Our ref: DOC20/509024

Senders ref: SSD10425

**Subject: Clarification on BDAR or BDAR Waiver for Tallawong Station Precinct South – Stage 2 Detailed Design (SSD10425)**

EES has reviewed the Flood Impact Assessment report (FIA) prepared by AECOM dated 16 April 2020 and considered that the report is inadequate due to the following reasons:

FIGURE B5 FLOOD RESULTS EXISTING CASE - 1% AEP

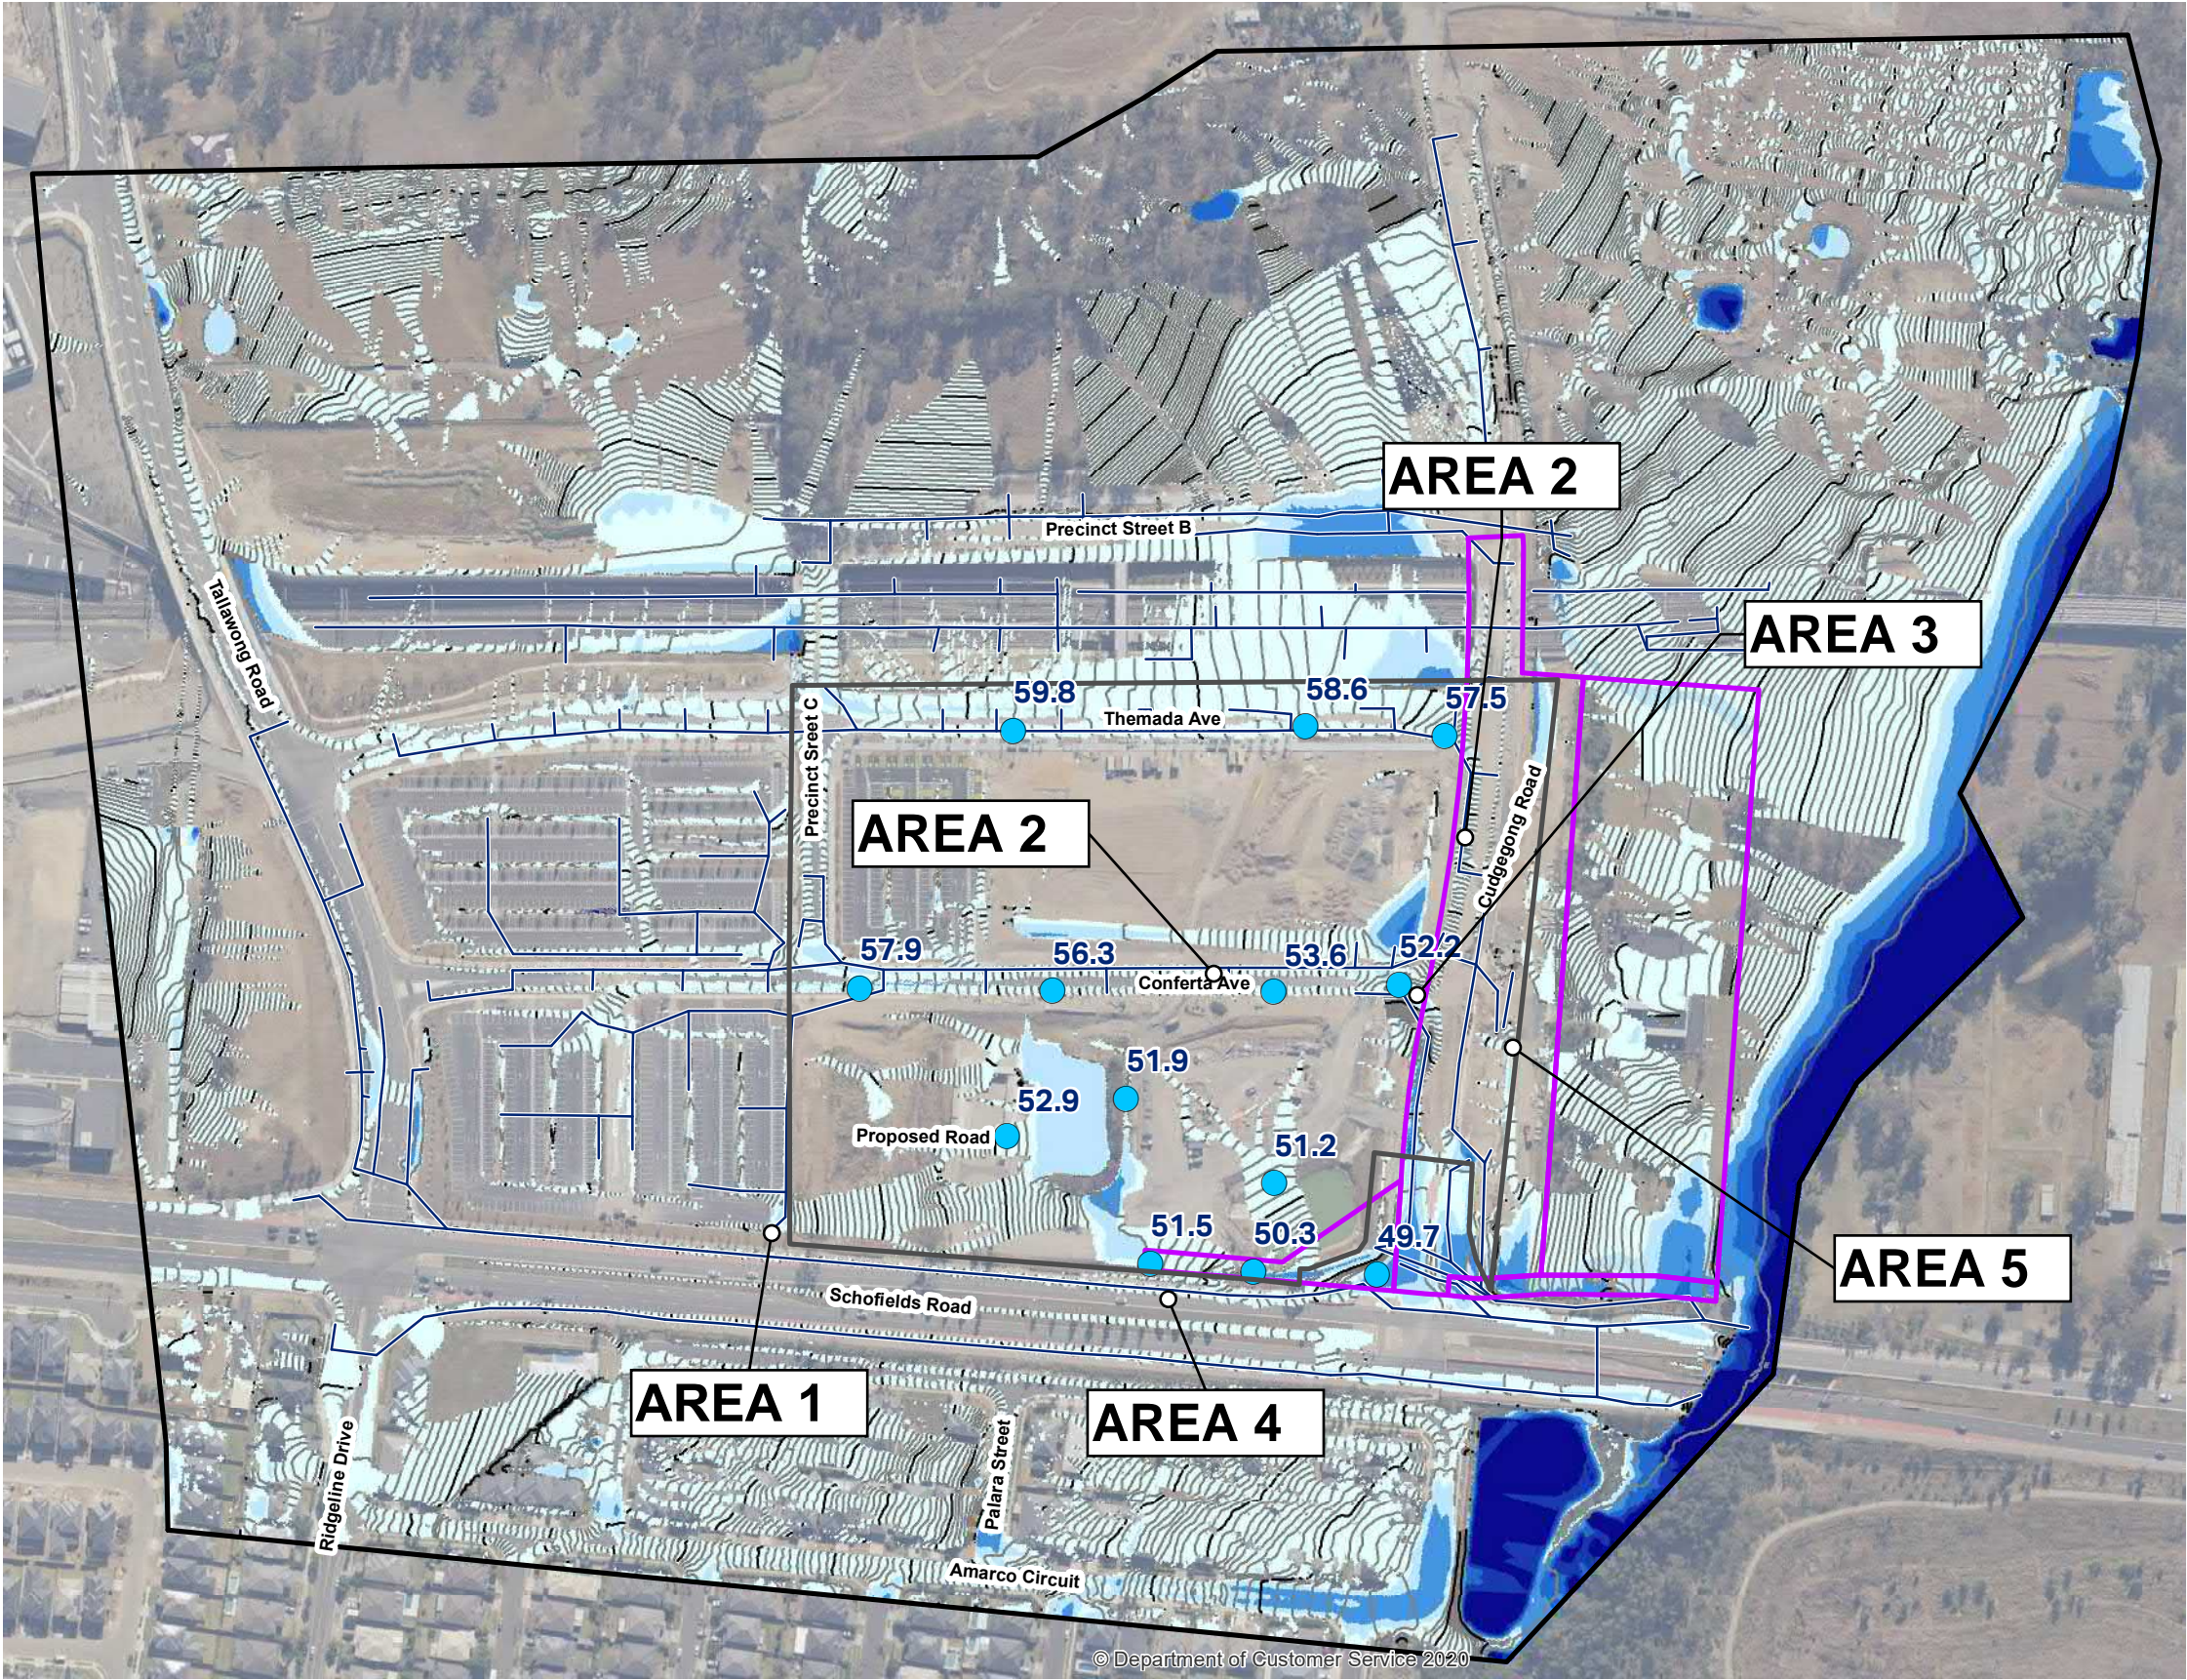
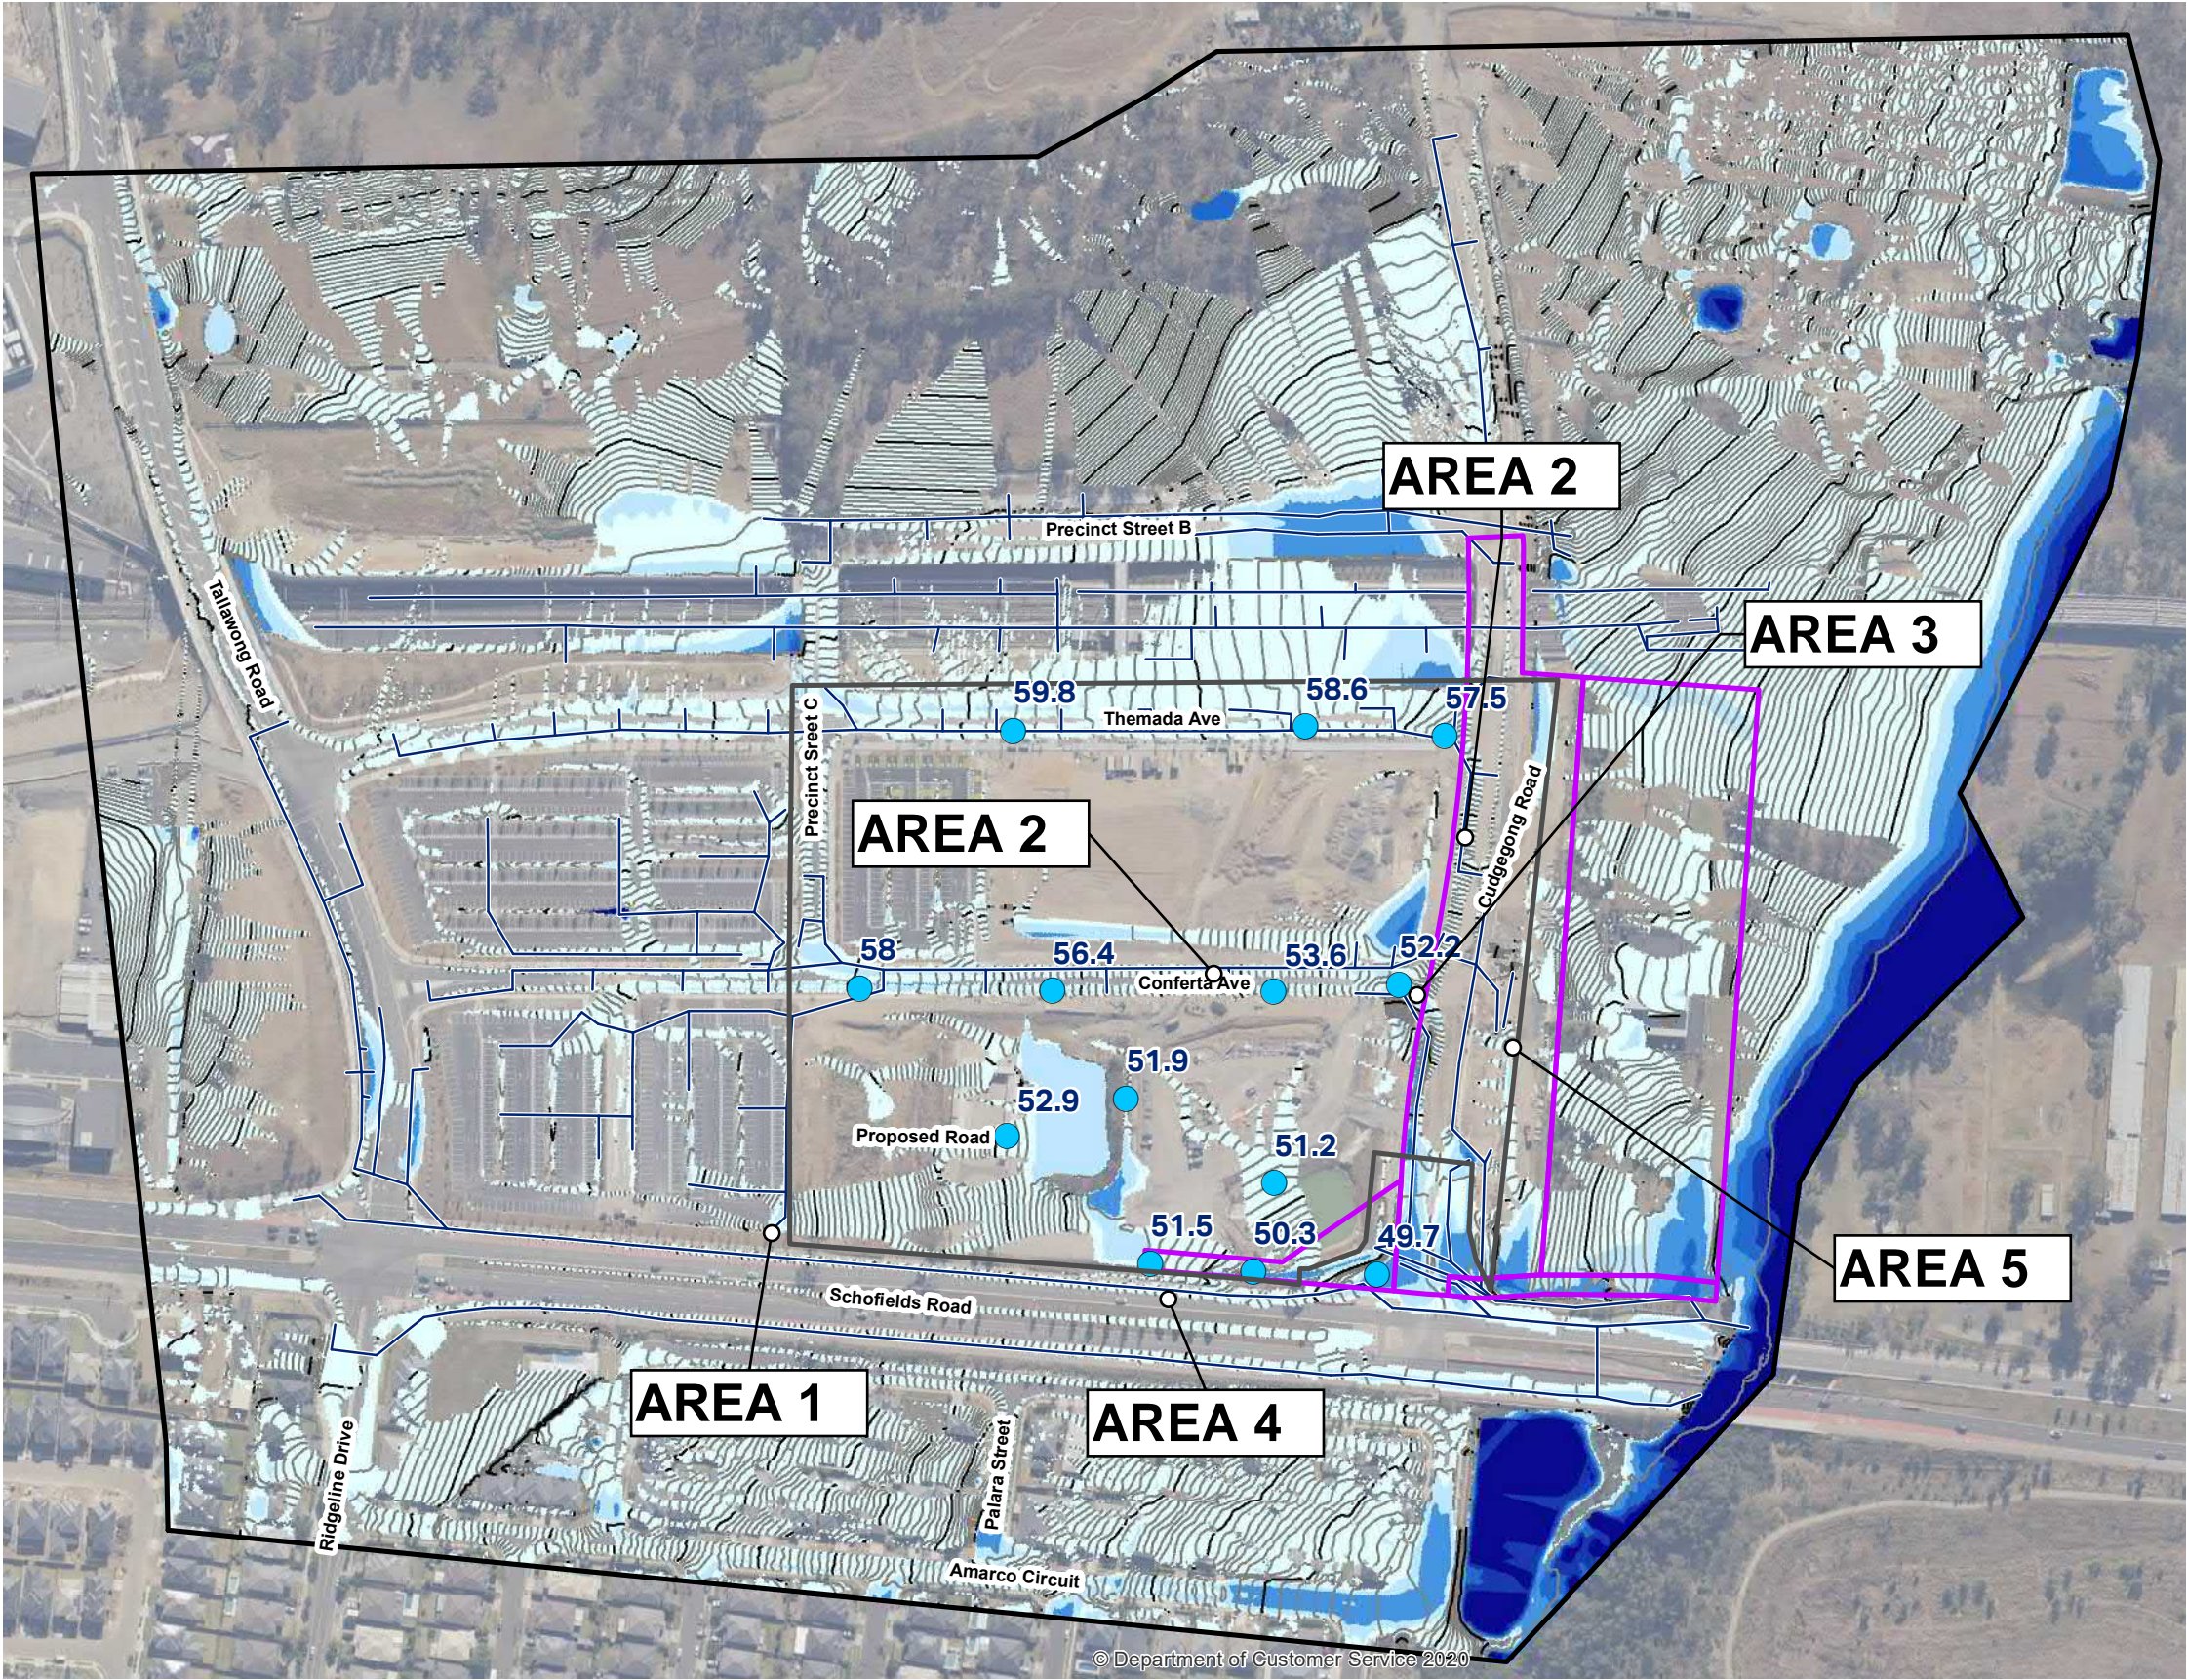
- the report provides no information on existing flood behaviour
- the report lacks details on model results
- not clear what is the extent of the model
- the limit of maps does not show the impacts of development outside of the site, the assessment should map the site and adjacent areas (i.e. to Second Ponds Creek to the west and at the inflow locations where the boundaries of the model were set up).

It is acknowledged from the brief discussion in the report that the consultant has undertaken a rainfall on grid TUFLOW modelling. However, the purpose of a FIA is to outline the flood risk at the site and outline how this risk is to be managed. This would include addressing the following floodplain risk management aspects to assist and guide decision-making at this planning stage:

- existing flood behaviour for the full range of flooding
- impact of development on flood behaviour the full range of flooding
- impact of flooding on development the full range of flooding and assess the compatibility of the proposed development with flood risk
- emergency management consideration (if applicable).
